A19 Downhill Lane Junction Improvement

Scheme Number: TR010024

7.14 Applicant's Responses to Written Representations

Regulation Number:	Rule 8(1)(c)(i)
Planning Inspectorate Scheme Reference	TR010024
Application Document Reference	TR010024/APP/7.14
Author:	A19 Project Team, Highways England & Jacobs

Drawing Title **LAND TAKE**

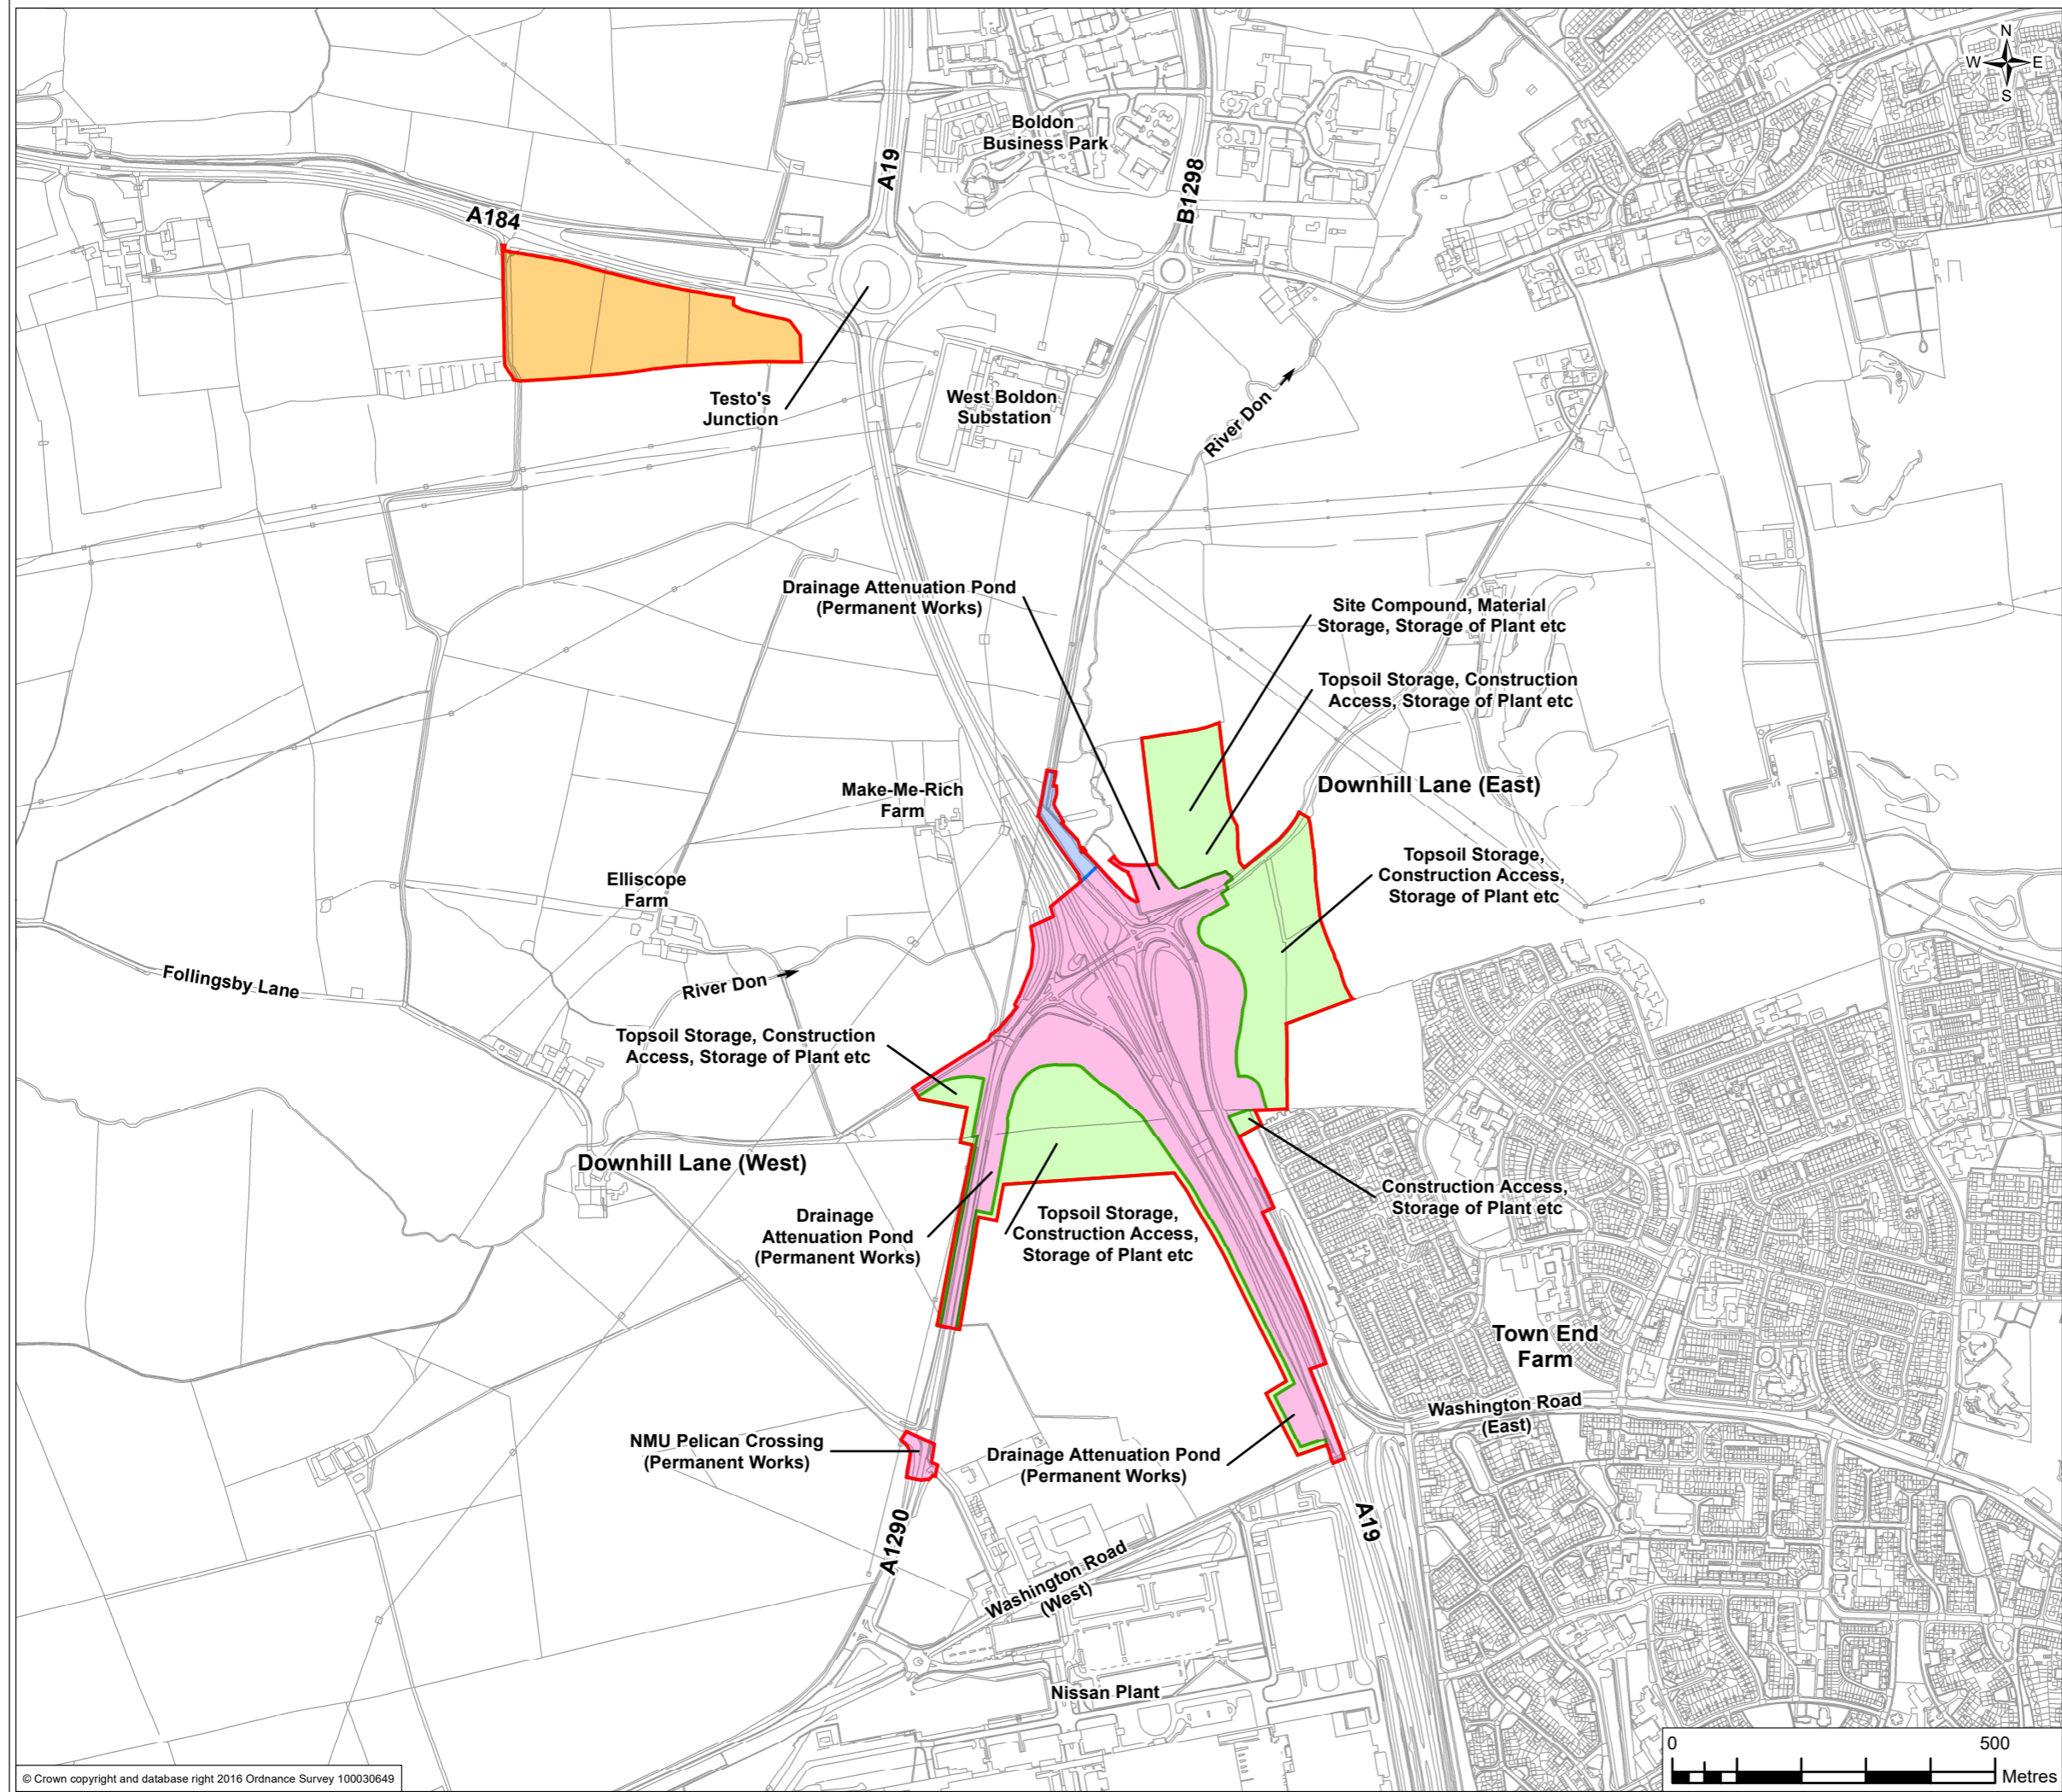
Extract	Applicant Response
	<p>paragraphs contained in Schedule 4 of that Order.</p>
<p><i>Letter dated 27 August 2019:</i></p> <p>Parcel 1/7a proposes a permanent land acquisition on a substantial parcel of land immediately to the east of the A19. We understand and accept that some land will be required to facilitate the works, we do not however agree with the approach taken in relation to the need for land for the NMU route. IAMP are currently in the process of consultation on the proposed DCO for IAMP Two. The IAMP Two proposal also proposes a NMU route. If the IAMP Two DCO does come forward then the proposed NMU route for the Downhill Lane DCO will not be required. We believe that there should be a more combined approach between the two separate DCO's. We note that Highways England have submitted additional information in relation to this and we would welcome the Inspector accepting these as amendments to the DCO and included in the Evidence Library.</p>	<p>The Applicant has taken all reasonable steps to progress an integrated NMU provision. Having considered the queries from the Examining Authority in the initial hearings regarding the integrated NMU provision (on which see, in particular, AS-022 and AS-016), and having considered further the information currently available, the Applicant has concluded it will not progress the integrated NMU provision at this juncture.</p>

<p><i>Letter dated 27 August 2019:</i></p> <p>Parcel 1/7b is land further within our control that is proposed for temporary acquisition. Highways England taking control of this parcel of land will have a major impact on delivery of the proposed housing scheme – it will dictate the phasing of the development site and also the sale of the land to a housebuilder.</p>	<p>Noted. The Applicant will continue to meet with Hellens and the Natrass family to minimise the impacts of temporary possession of plot 1/7b so far as reasonably practicable. The Applicant would refer to its comments concerning the Local Plan, and the notification of development above in this context</p>
<p>Environment Agency</p>

Drawing Title: **PROPOSED DRAINAGE DESIGN**

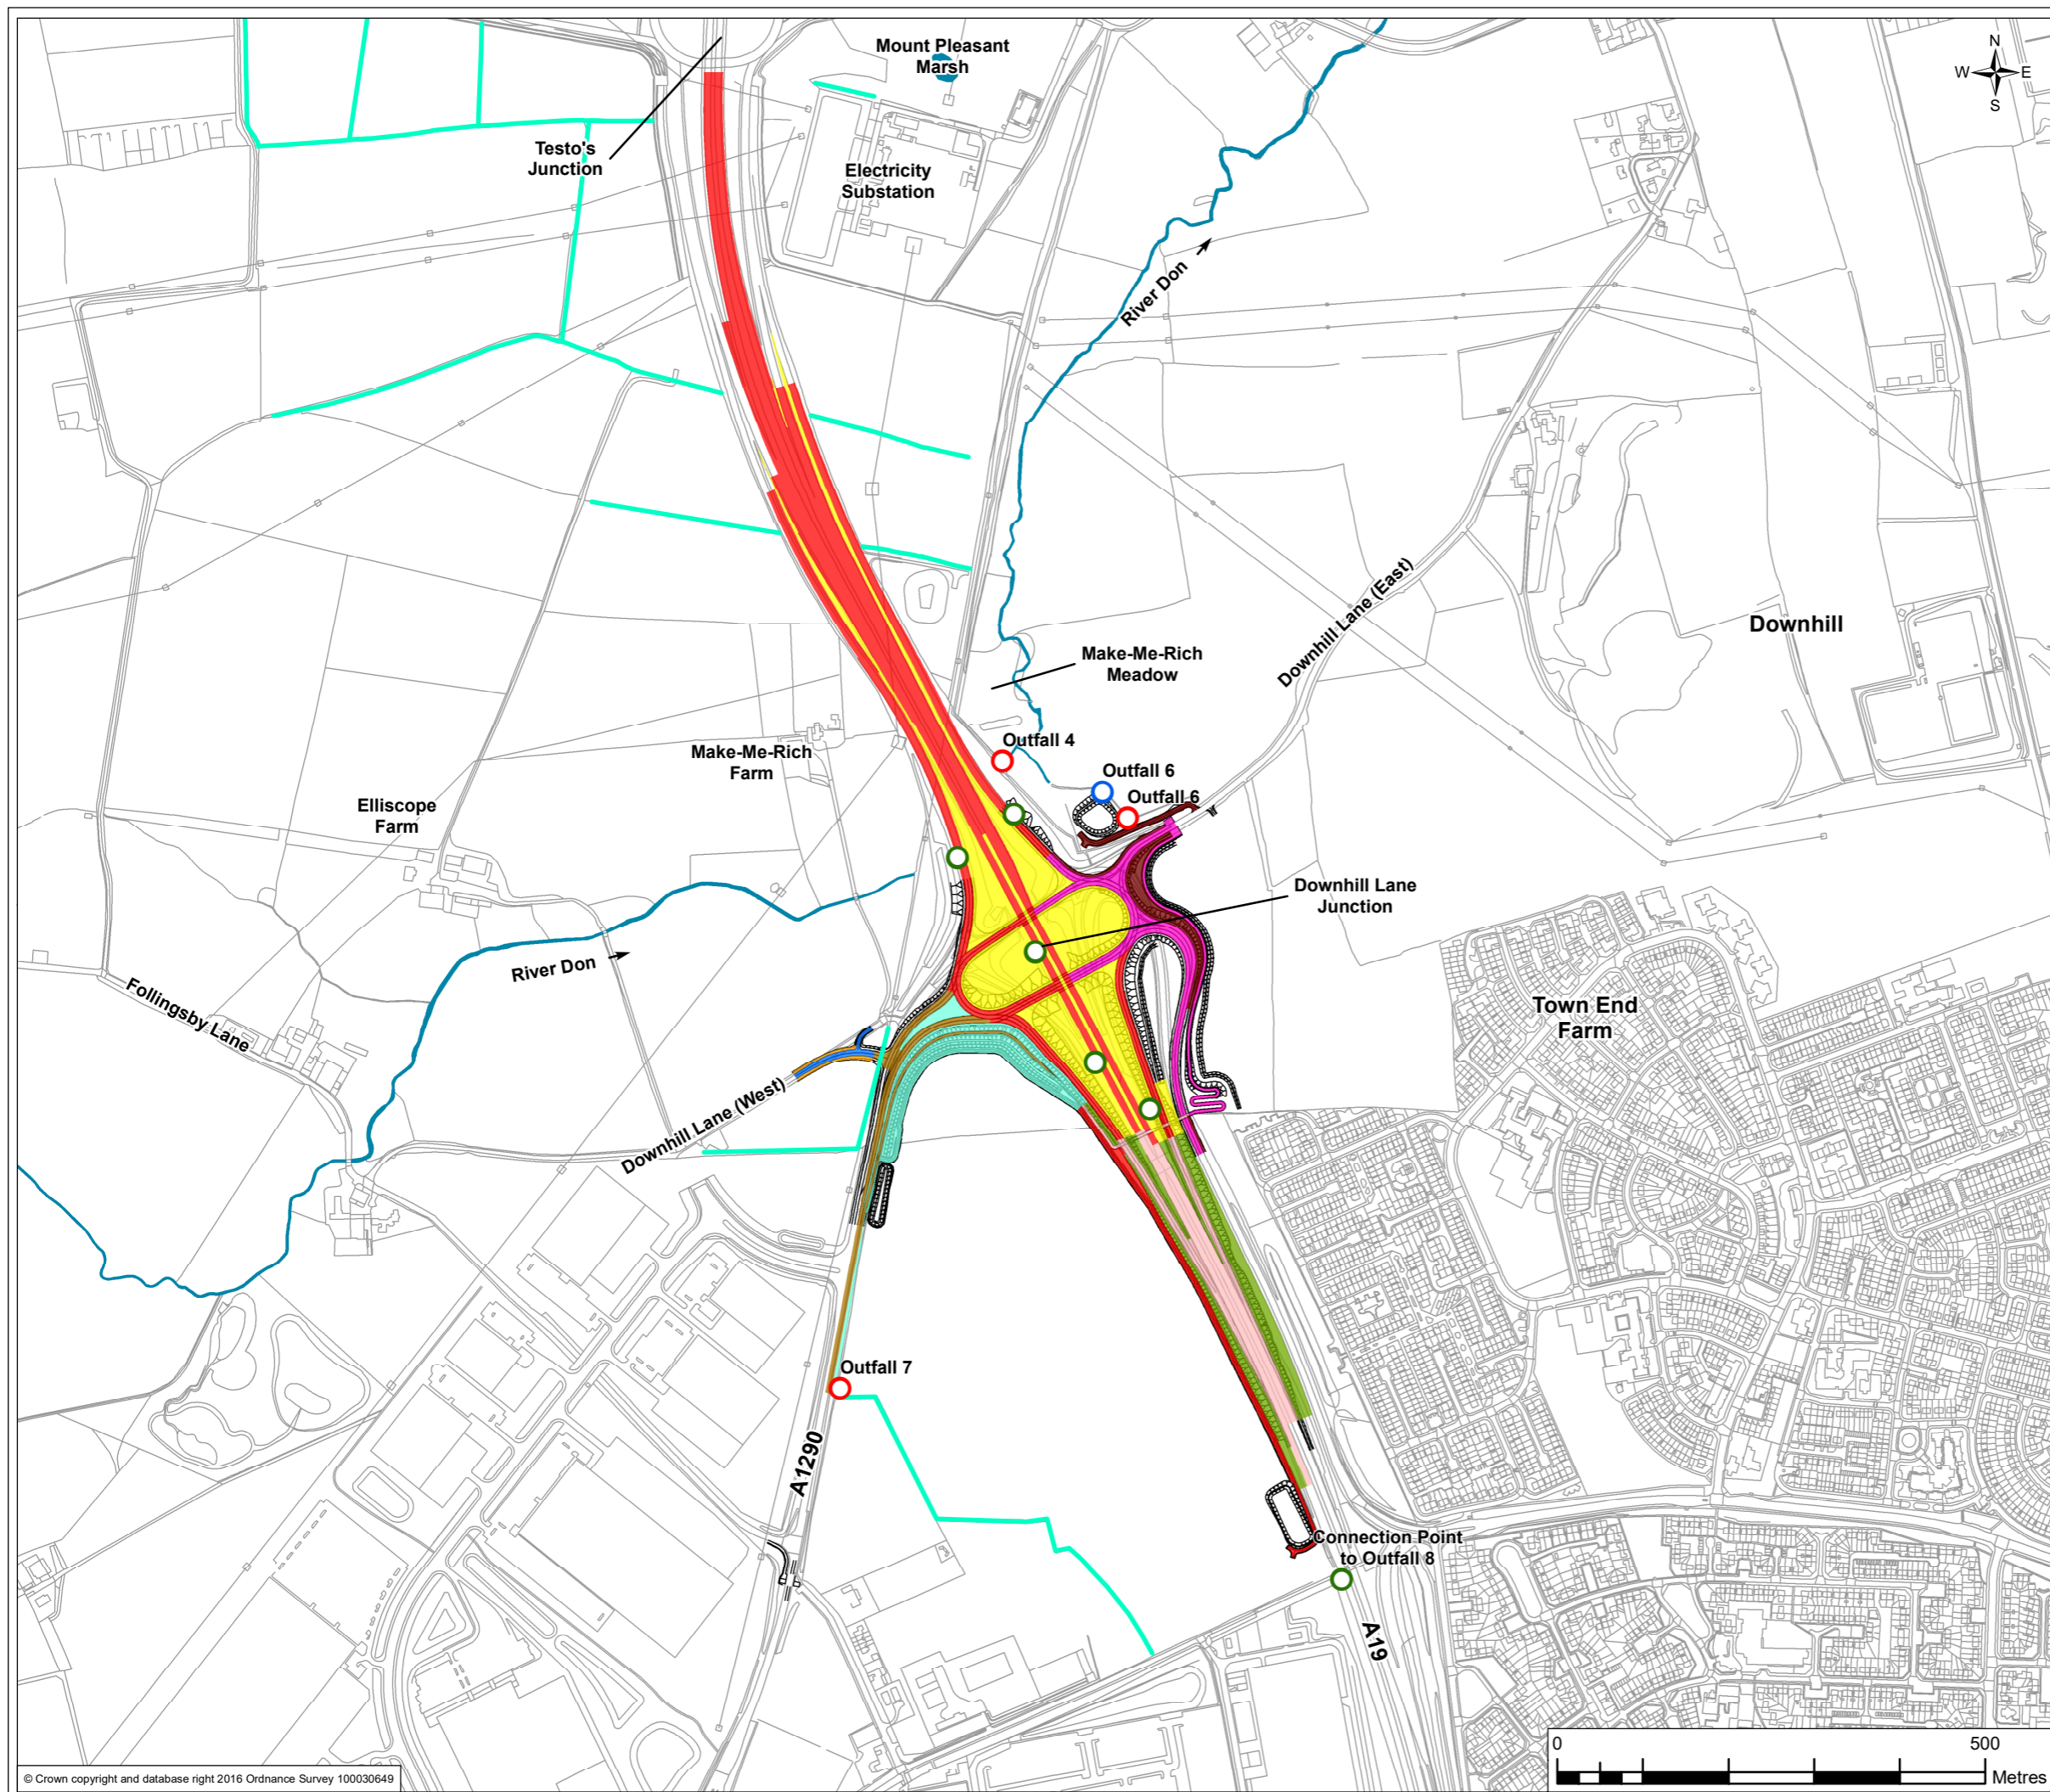
Extract	Applicant Response
<p><i>Letter dated 27 August 2019:</i></p> <p>In relation to parcel 1/7c, this is the only link to a stream to the north of the development site within Hellens Land Ltd control. We have undertaken an initial flood risk assessment on the proposed development site and we foresee the connection for the surface water drainage. Timings of the DCO being on site and our proposed timing for delivery of the housing development could potentially clash and therefore this parcel of land being permanently acquired by Highways England would impact upon our connection point – the lack of a connection point for surface water drainage out with our control could have major cost implications for the development. We strongly object to the whole of this parcel of land being permanently acquisitioned unless we retain rights to connect into the water course currently within our control.</p>	<p>The Applicant agrees in principle to the provision of rights to allow connection into the tributary of the River Don in plot 1/7c should Hellens secure consent for their development site from the relevant authorities and approvals from the Applicant on ensuring the safety and efficient operation of the strategic road network. The Applicant notes that on completion of construction, the ownership of plot 1/7c will be transferred to South Tyneside Council. The Applicant will consult with the Council to agree the necessary provisions are acceptable.</p>
